**ADC Planning Consultation
Conservation/Design Officer Response**

Application Number	BR/280/17/PL
Address	Land adjacent to 8 Mead Court Mead Lane Bognor Regis PO22 8BL
Description	1 No. dwelling. This application may affect the setting of Listed Buildings & affects the character & appearance of the Upper Bognor Road & Mead Lane Conservation Area.
Case Officer	Mr R Temple
Date	10 TH January 2018

Front Elevation

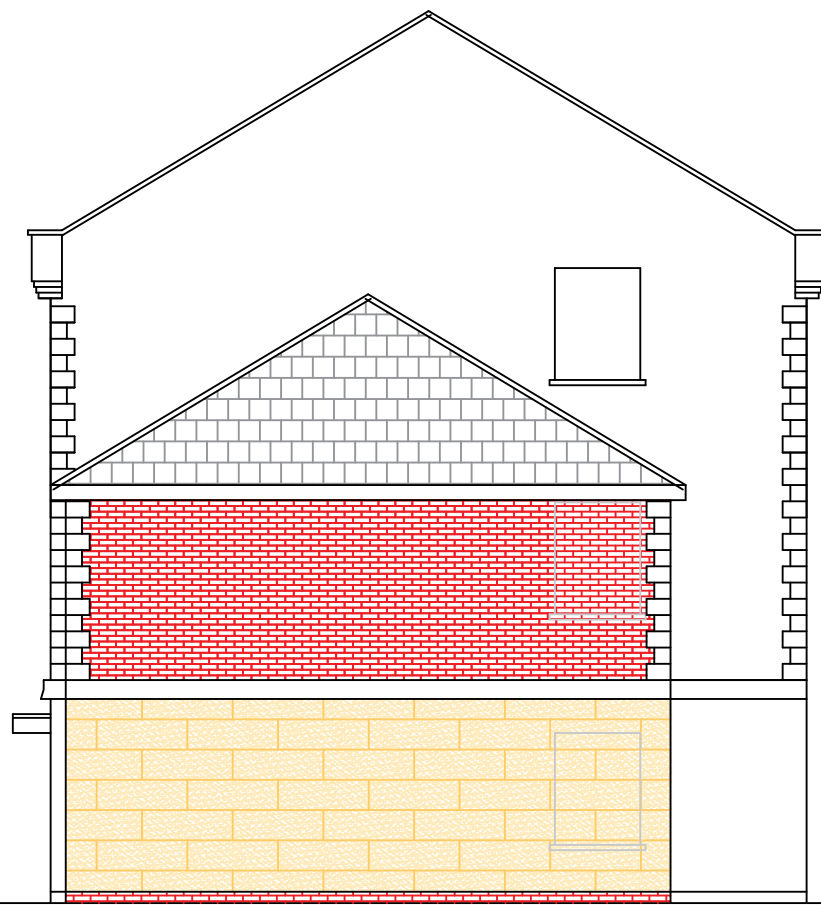
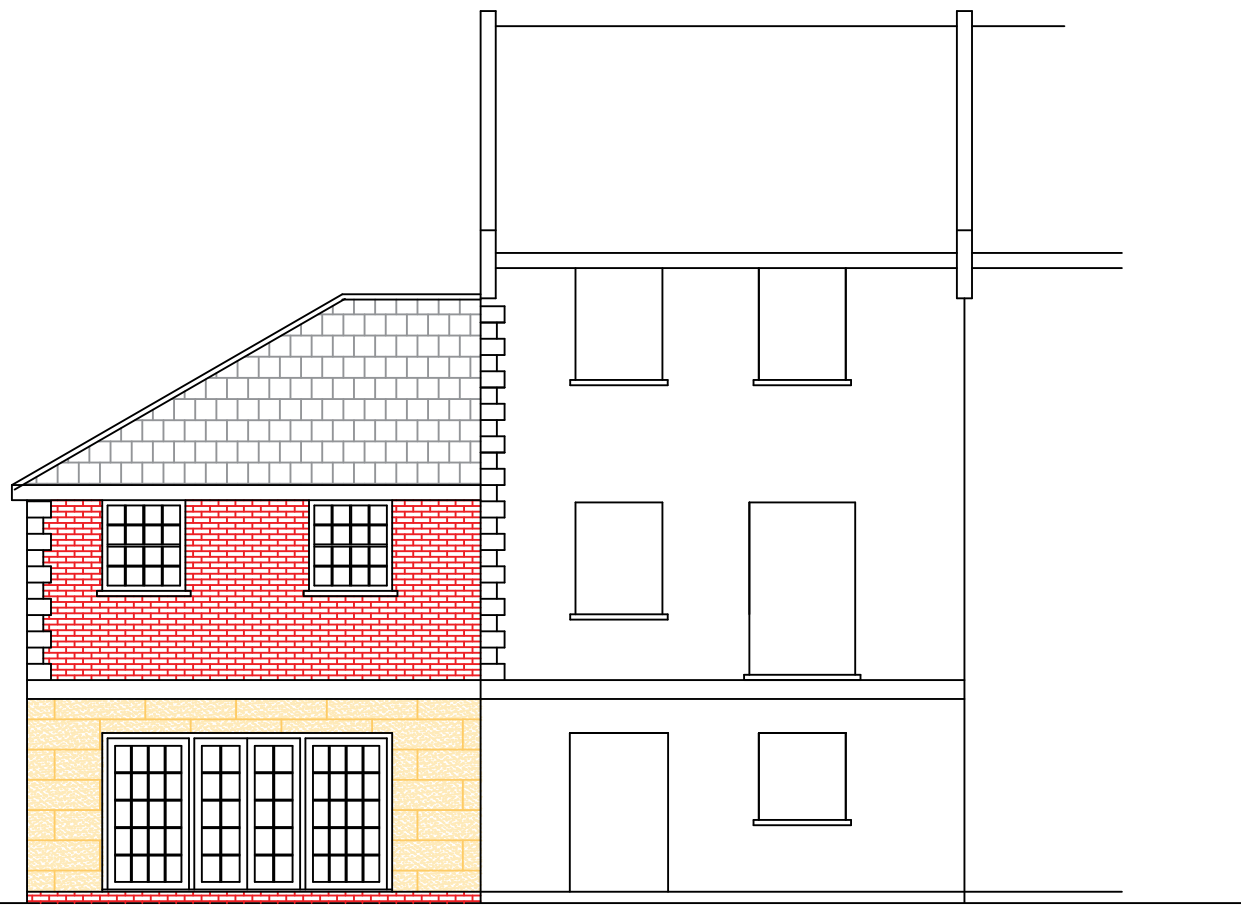
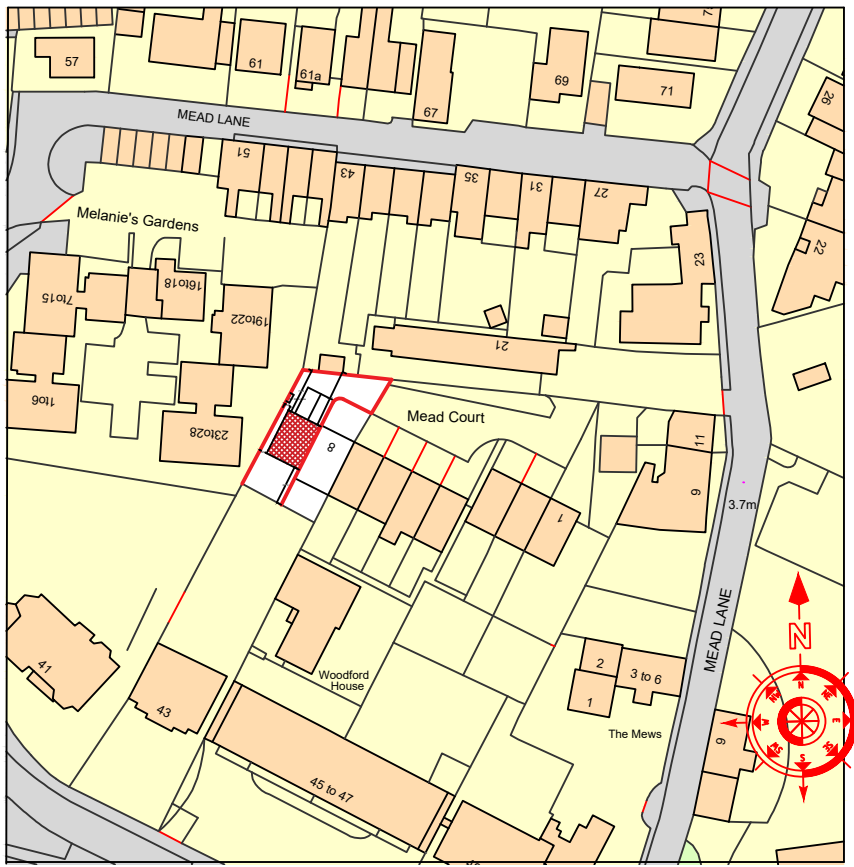
The proposed design is at odds with the existing terrace in terms of roof profile, material, having a hipped roof, and detracts from the overall visual massing of the existing terrace, and does not respond to the existing building, nor its setting. The application also affects the setting of two listed buildings (above), and in addition, would be visually intrusive within the Conservation Area, being visible from the Upper Bognor Road between the two listed properties (above).

Block plan 1 : 500

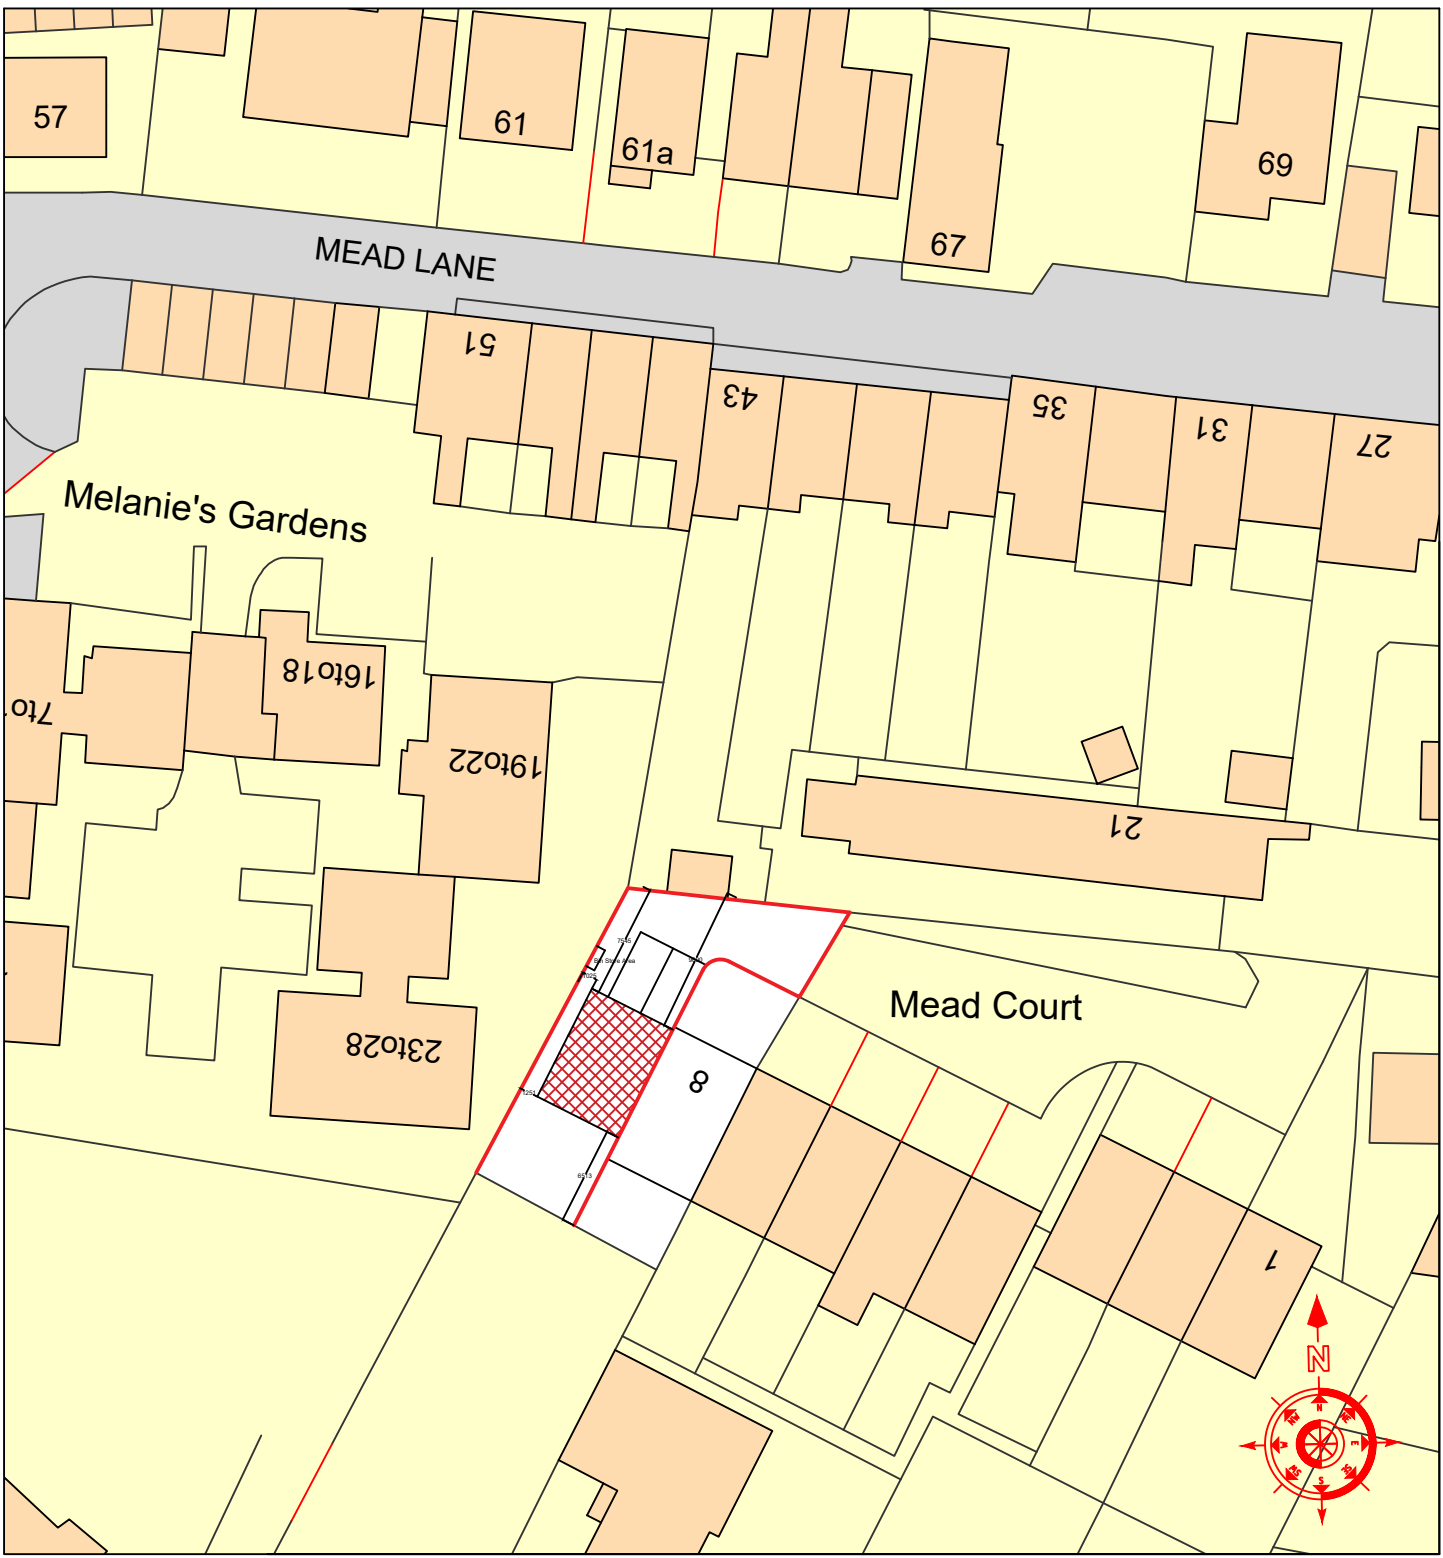
The proposal would also compromise an important feature of the Conservation Area, namely a flint wall which runs along ,Meads Lane. This wall is likely to be the original curtilage boundary of 43 Redgate House, and is shown on the 1875-1890 historic map.
